Your Ref: OWPC18272
Our Ref: P/36/18/PL 23-03-2018
Please ask for:
Andrew Wood

Demolition & erection of 1 No. dwelling with associated vehicle hard standing area.
30 Lagoon Road Pagham

Site Plan (scale 1:500)

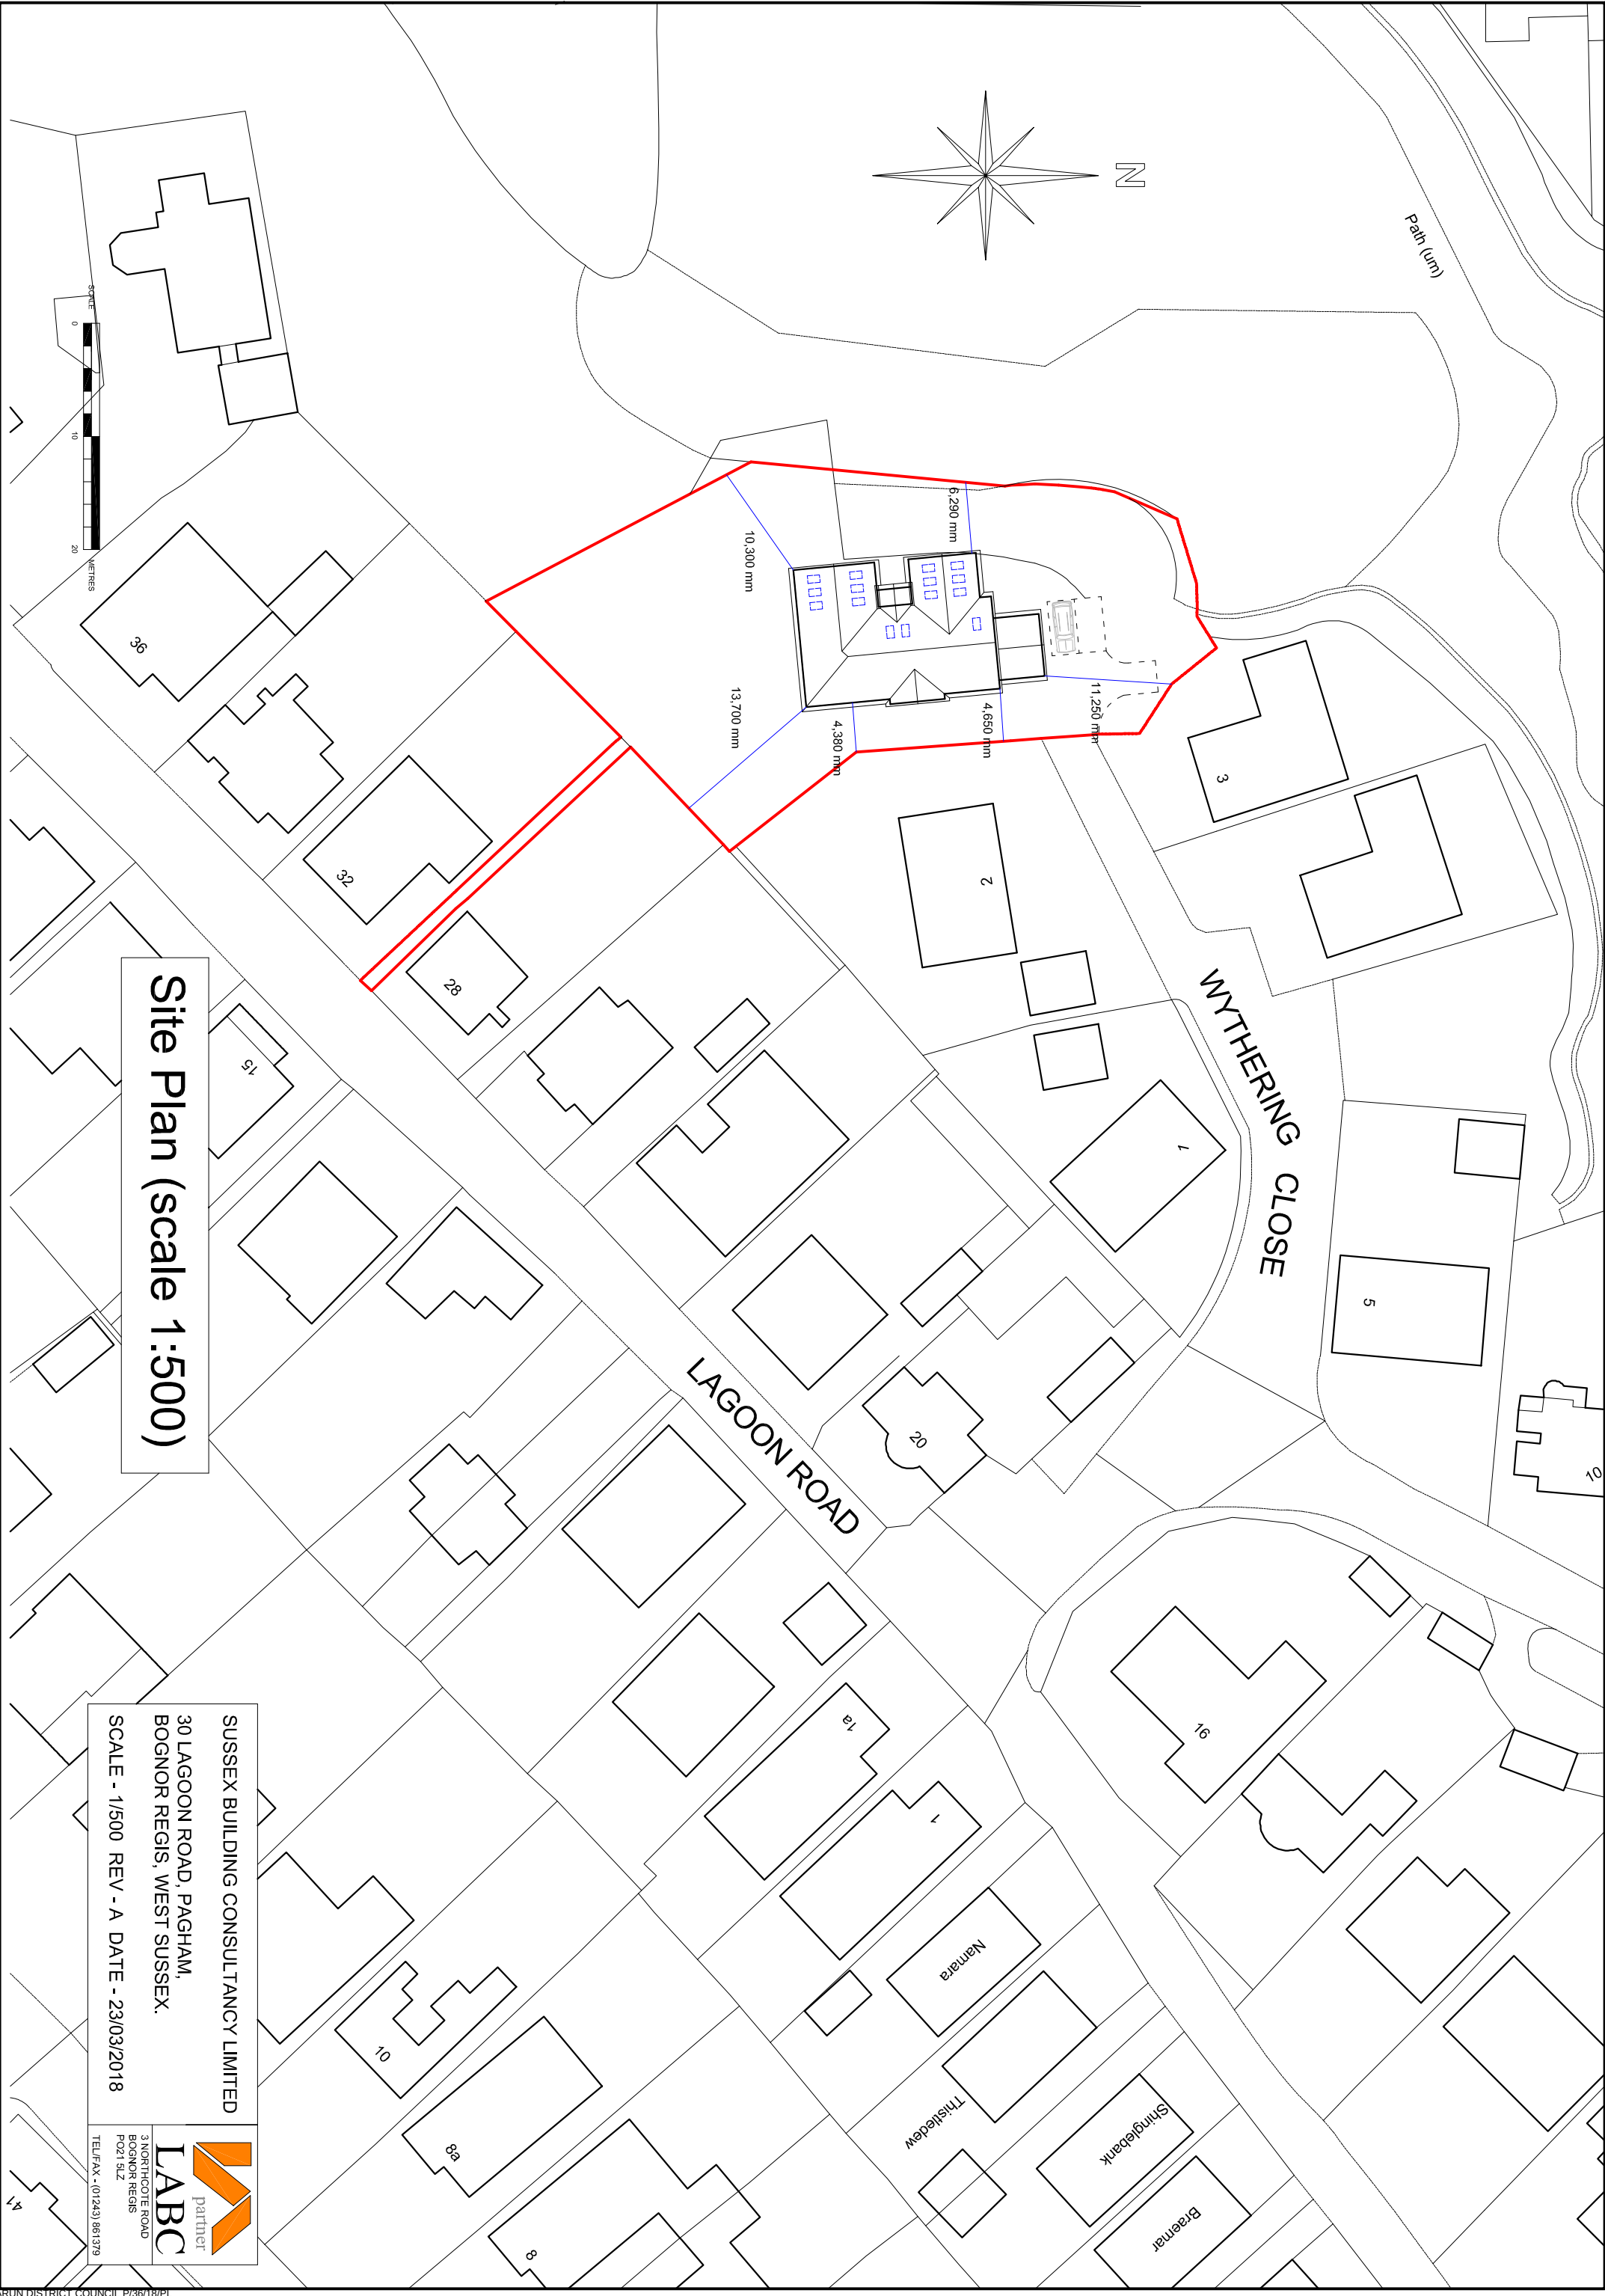
Enjoying a plot of some 1,160m² the property at 30 Lagoon Road, Pagham can be accessed via a narrow, overgrown footpath off Lagoon Road, with vehicle and pedestrian access from the rear of the property into Wythering Close, Pagham, marked blue on the plan which is in your possession. The area marked blue on the plan measures a narrow 3.5 metres in width and approx. 24 metres long and the cost of maintaining this access way in a reasonable state of repair is the responsibility of the owner of No.2 Wythering Close, plus two other owners, plus the owner of 30 Lagoon Road, all in accordance with a Land Deed signed on 23rd July 1997. There is no footpath along any part of Wythering Close which could create safety concerns.

The demolition of the existing property at 30 Lagoon Road, the felling of the mature trees noted on the plan, the presumed removal of a mobile home and general site clearance, plus the construction of a new property, will undoubtedly put huge pressure on the existing access way road surface if indeed the owner is intending to use the Wythering Close access way for construction traffic. This is not clear on the application and it is possible that construction traffic will use an alternative route negotiated by the applicant so perhaps this could be clarified before planning permission is granted.

In addition, it is noted on the site plan there is provision for only two hard standing parking spaces. From the ground floor plan submitted it is presumed that the intended new construction will be a two-family home because of the two planned kitchen areas (see proposed floor plan).

A two-family home would generally suggest 3 vehicles would be in use. Users cannot obstruct the area marked blue on the plan and there is no space for visitors to the property at 30 Lagoon Road to park in the Wythering Close cul-de-sac which is already congested. Given that the plot size is a generous 1,160m² would it not be prudent to suggest more space be allocated within the site for parking for residents and visitors to park and with sufficient space to turnaround to exit? Having a frontage with a nice view is not much good if you are restricting space for owner and visitor vehicles to the side and rear.
